29th June 2022

Application: A/114/22/DOC
Location: West End Cottage Roundstone Lane Angmering BN16 4AX
Proposal: Approval of details reserved by condition imposed under ref A/144/15/PL relating to Condition No 15 - ecological enhancement scheme

We have reviewed the Ecology Comments and Management Plan (Ethos, May 2022), submitted to meet the requirements of Condition 15.

Figure 1: Management Plan and ecological enhancement measures

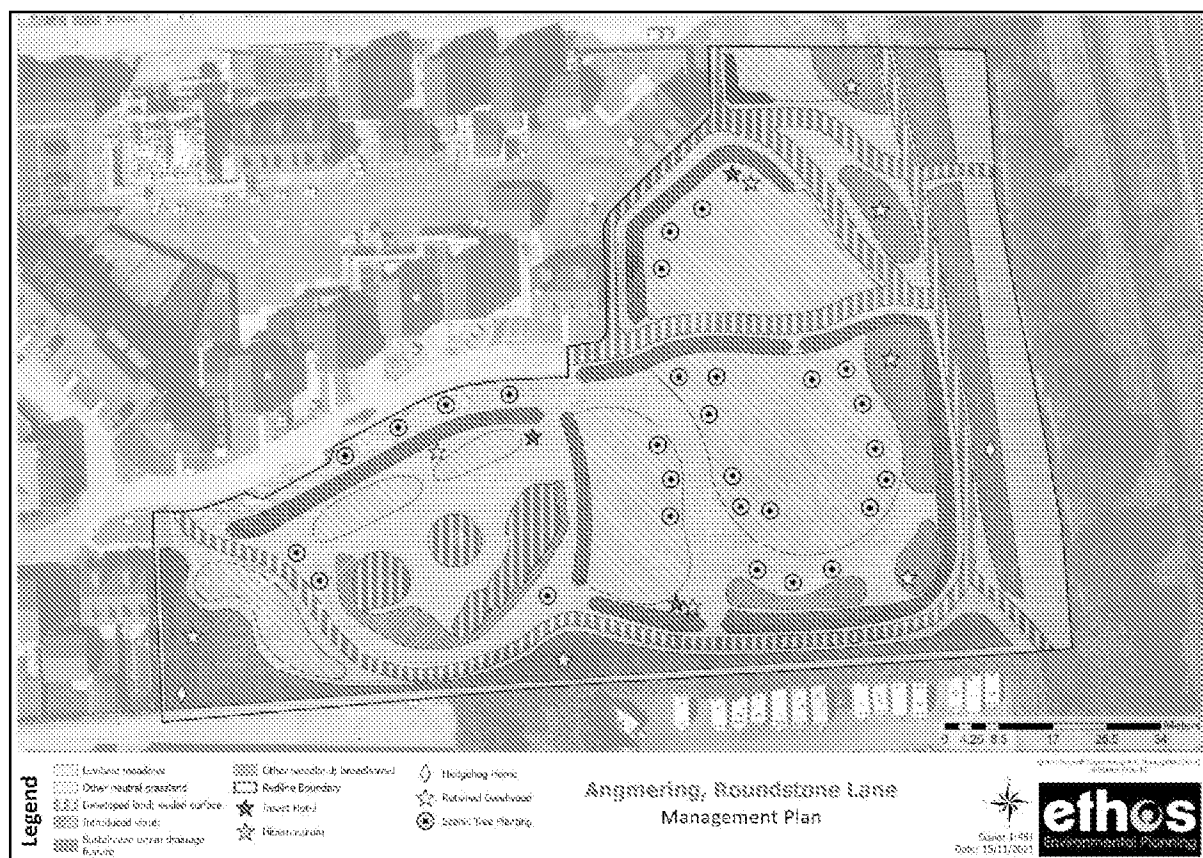
Although we support enhancements, implementation, and aftercare strategies of two hedgehog homes, three insect hotels, log piles, a meadow grassland, woodland planting, and EL1 mixture for amenity grassland areas, we are not satisfied that the Ecology Comments and Management Plan (Ethos, May 2022) includes the detail required by this Condition. Although the requirements for condition 15 states that *"shall include the installation of bat boxes throughout the site"*, no reference to the installation of bat boxes has been made within the Ecology Comments and Management Plan (Ethos, May 2022). Therefore, confirmation of the installation of an appropriate number of bat boxes,

along with further technical information (product details) and appropriate locations, should be submitted in an updated map/plan. In addition, we also need to see the species composition/list for the screen and woodland planting.

Furthermore, within the Ecology Comments and Management Plan (Ethos, May 2022), the map “Figure 1. Management and ecological enchantment measure” does not clearly show any of the proposed enhancements. Therefore, the updated map/plan should also clearly demonstrate the appropriate locations of all enhancements proposed.
